10<sup>th</sup> October 2024

**OBJECTION TO PLANNING APPLICATION FOR ERECTION OF EXTENSIONS AND ALTERATIONS AT 9 HOLLYBANK AVENUE, UPPER BATLEY, BATLEY, WF17 0AQ**

**LPA REF: 2024/92465**

DRG:
EXISTING FLOOR PLANS & ELEVATIONS

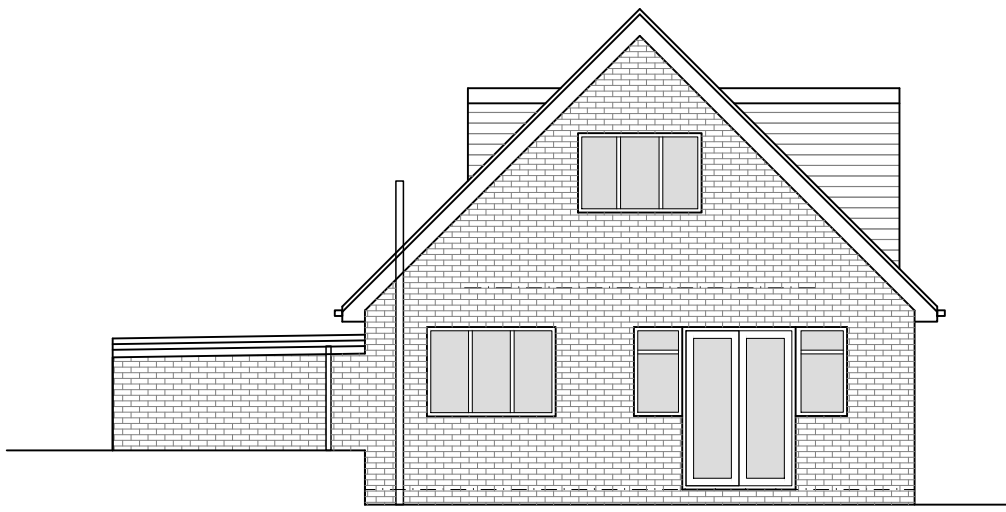
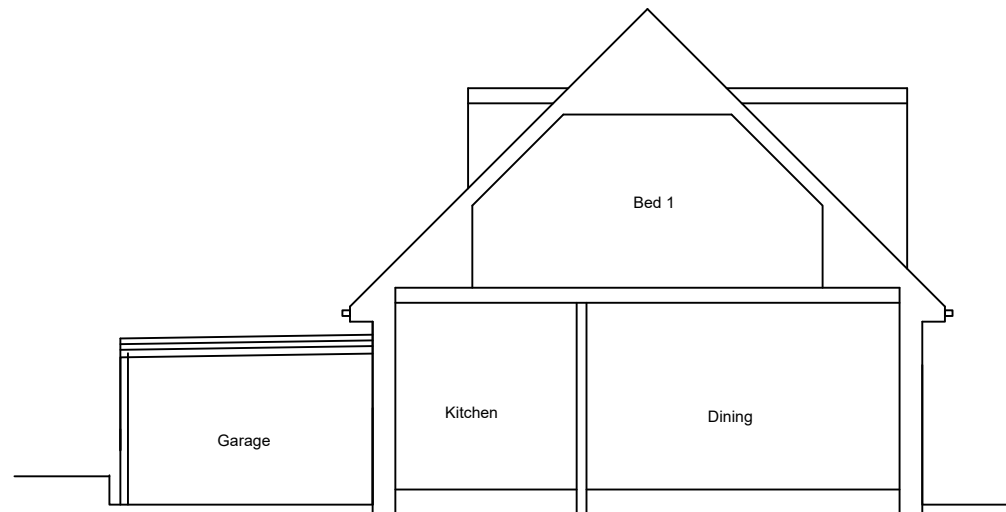
The proposed first floor side extension would significantly alter the original character and appearance of the dwelling when viewed from the street, as demonstrated in the images below. The dwelling would lose part of its original charm which is found within its distinctive style and design. The first floor side extension would increase the form and massing of the property from a visual perspective, and it is therefore considered that the resulting property would be out of keeping with the other similarly designed properties on Hollybank Avenue.

DRG:  
PROPOSED FLOOR PLANS & ELEVATIONS

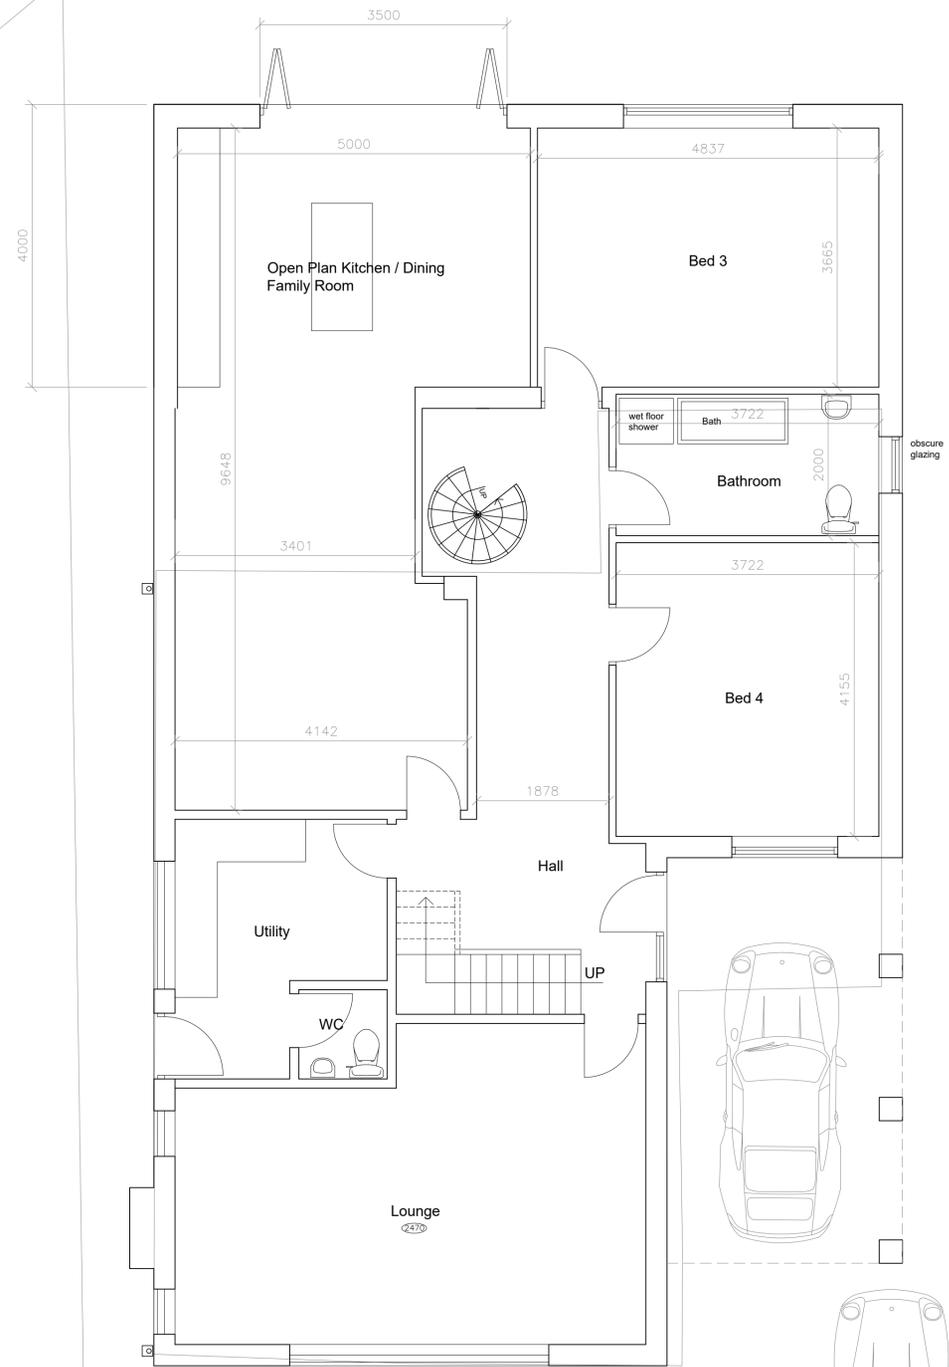
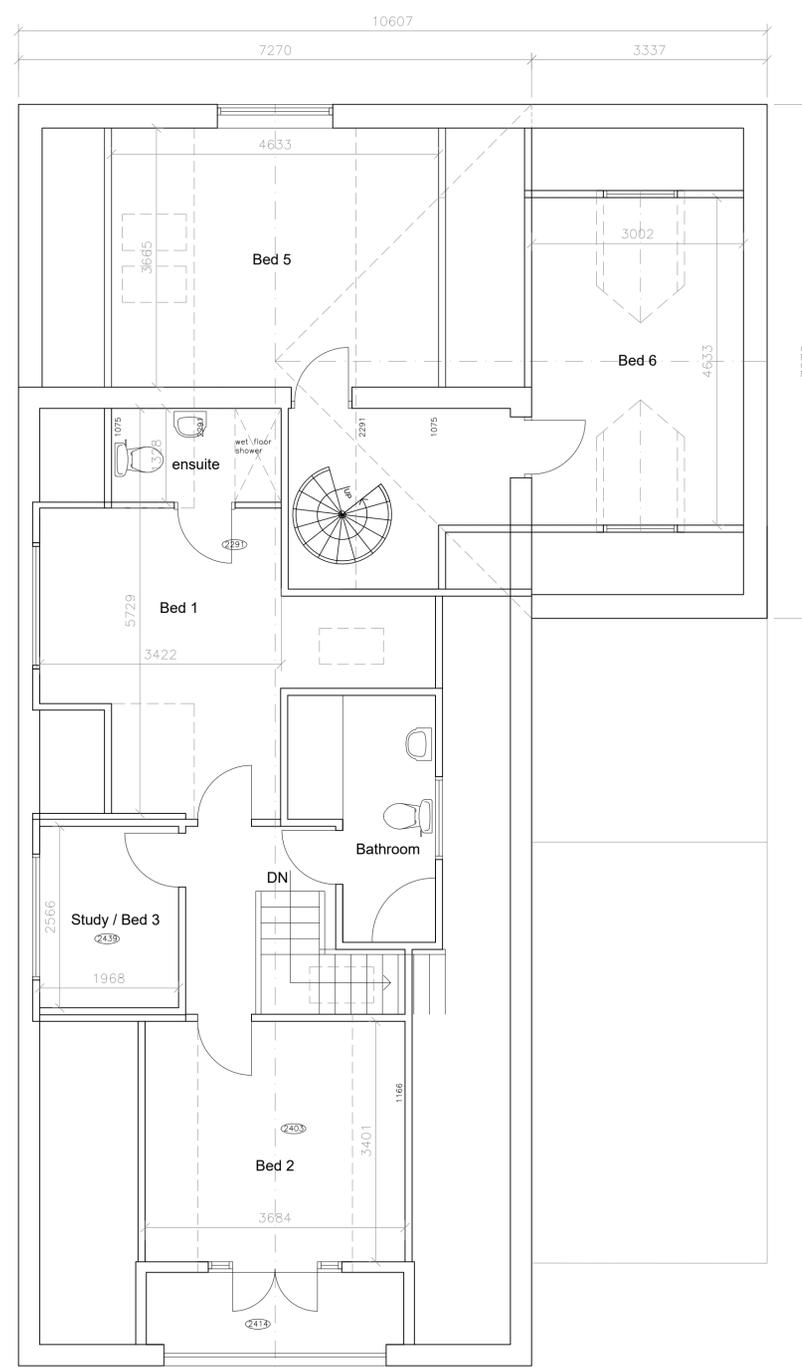
The original house is a modest two-bed dwelling. However, the proposals would result in a large six-bed property. The two-storey rear extension would project out by 4 metres and would extend across the entire width of the original property. In addition, the first floor side extension would extend over the existing garage and part of the existing car port. Both the footprint and the volume of extensions proposed would increase the size of the property significantly. As a result, it is considered that the cumulative amount of extensions proposed would dominate the original dwelling, which in turn would have a detrimental impact on the character and appearance of the original dwelling and street scene.

- The proposed extensions would be disproportionate to the size of the original house and garden (as discussed above).
- The proposed two-storey rear extension would not be separated from the property boundary by at least 1.5 metres. The separation distances between the extensions and the shared boundaries are 1.2 metres and 1.4 metres respectively. As a result, it is considered likely that the two-storey extension would have an overbearing and overshadowing impact on the rear garden of No. 7 Hollybank Avenue (not our client's property).

- The proposed extensions would not be visually smaller in relation to the original house (as discussed above).
- The proposed first floor extension would not have a roof design that follows the form of the existing roof. The first floor extension would result in an incongruous feature at the side of the dwelling that would detrimentally alter the existing roof form and increase the scale and massing of the dwelling to an unacceptable degree.

The properties along the western side of Hollybank Avenue are set back from one another. As a result, the applicant's southern elevation already extends out along the shared boundary with No. 7, causing overshadowing and a loss of light to their garden. The proposed two-storey rear extension would add another 4 metres of blank wall along the shared boundary, increasing overshadowing and reducing light to an even greater degree.

proposed two-storey extension would significantly increase the expanse of blank wall facing No. 7's garden, which is likely to result in an increased overbearing impact and feeling of being 'hemmed in' by the applicant's dwelling to the detriment of No. 7's residential amenity.

The proposed plans show 3 parking spaces to be retained at the front of the dwelling. However, it is disputed that there is actually enough room to accommodate 3 spaces in reality due to the width of the driveway and the siting of the property boundary (see Google Street View below). If only 2 off-street spaces can be achieved, it is likely that additional cars will end up parking on Hollybank Avenue, possibly within the turning head, to the detriment of highway safety.

Furthermore, the proposals include 6 bedrooms, which is substantially more than 4 bedrooms where 3 car parking spaces are recommended. It is therefore highly likely that more than 3 spaces will be required for such a large property.

BLOCK PLAN 1:500

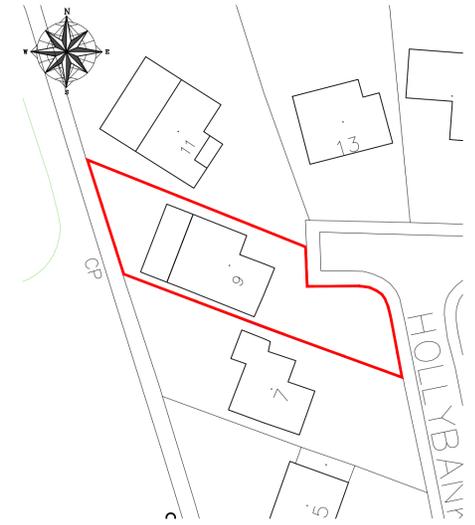
The size of the extensions proposed would reduce the size of the rear garden. This would result in a disproportionately small garden for such a large property, and presumably a family home. The property does have a good sized front garden. However, if this area of garden was overly domesticated e.g. the introduction of garden furniture, children's play equipment etc, due to the lack of space in the rear garden following the extensions, this would potentially cause undue harm to the visual amenity of the street (and would also likely cause additional noise and disturbance).
